Response to Planning Application

From: Arun District Council Greenspace

Application ref: BN/150/20/PL

Location: Land at Chantry Mead & Rear of 14 -18 Downview Road Barnham PO22 0EG

Tree Retention Protection Plan

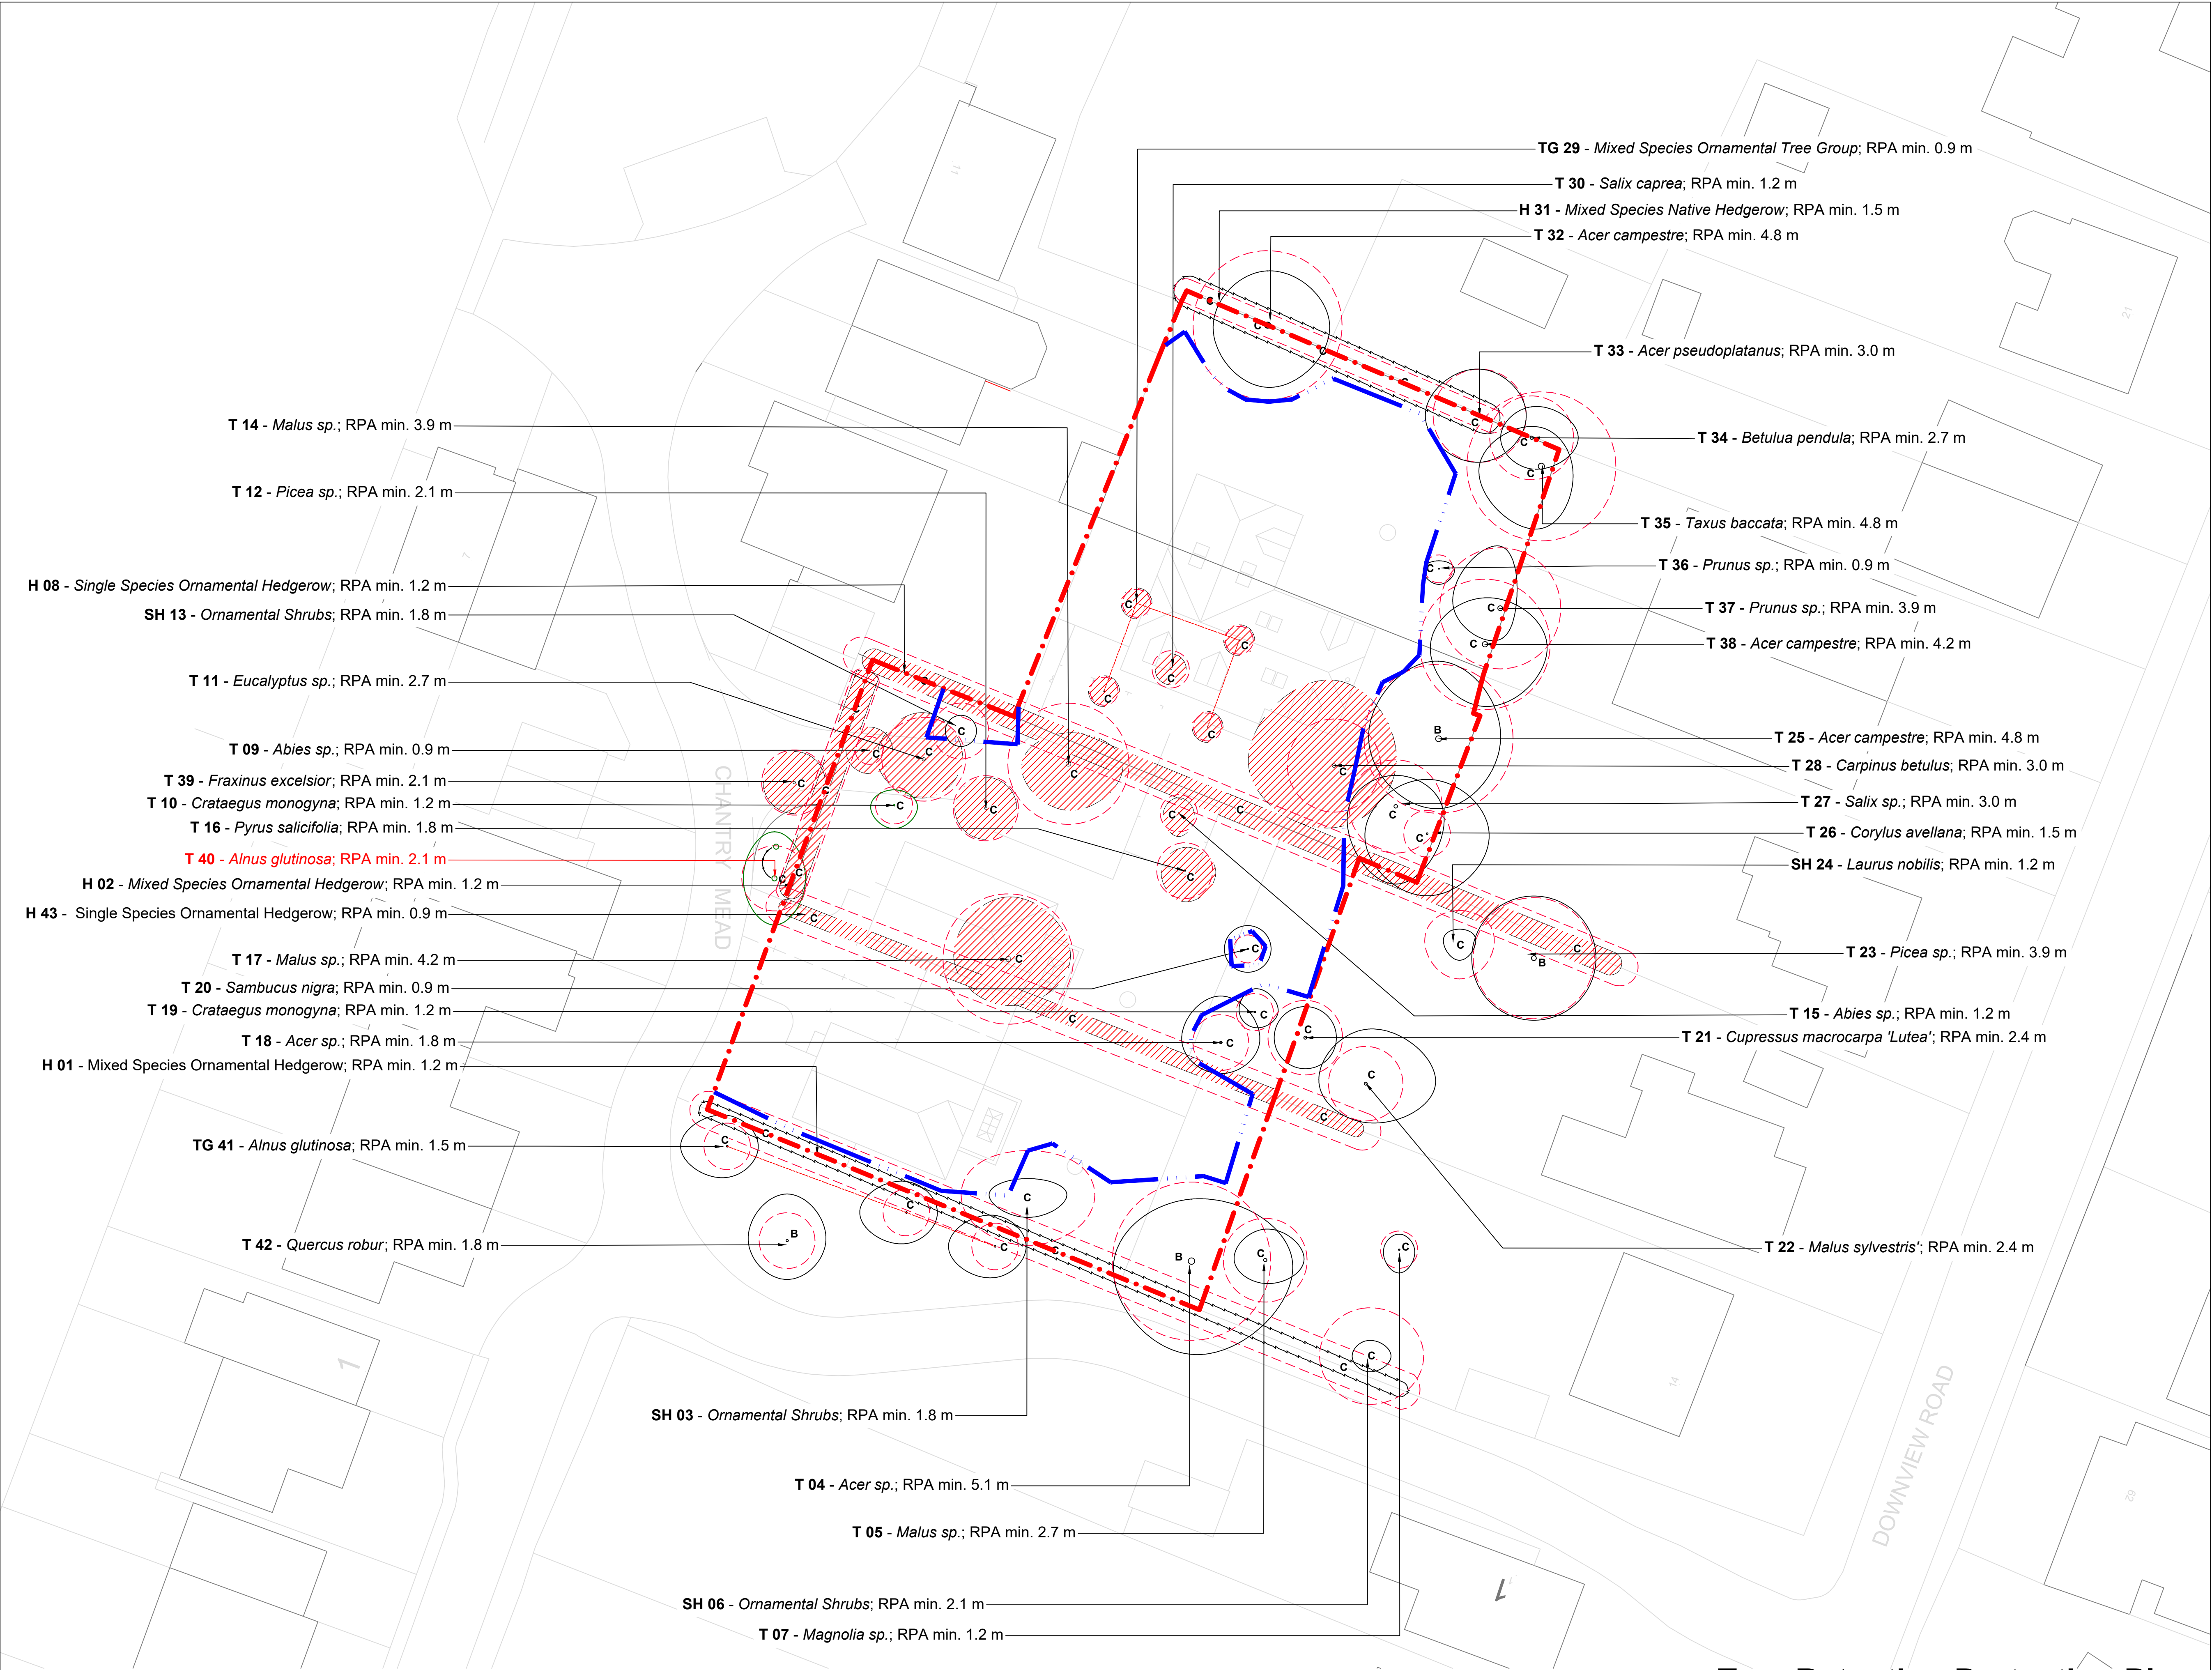
The NPPF para 124/127 relate to good design principles which equally apply to small infill and replacement development. The indicative site layouts and tree protection plans have made reference to indicative planting alongside tree retention. These details would require expanding in the form of a detailed planting plan and specification detailing species choice, actual plant quantities, planting densities and size at time of planting. Detail should also be provided regarding existing trees and boundary planting.

The resulting vegetation cover once cleared would not leave any considered valuable tree cover in this red line plot. Any trees to remain would need to be protected during any construction works, including trees outside of the boundary which could be detrimentally impacted by the works. Landscape provision would need to be specified to the new dwellings including native and ornamental to provide infill plus boundary screening as required. All proposed planting should be considered and its connection for biodiversity and habitat explored, with a biodiversity net gain following development. Trees specified should be at a size which allow instant impact, but which will establish and mature as the site develops.
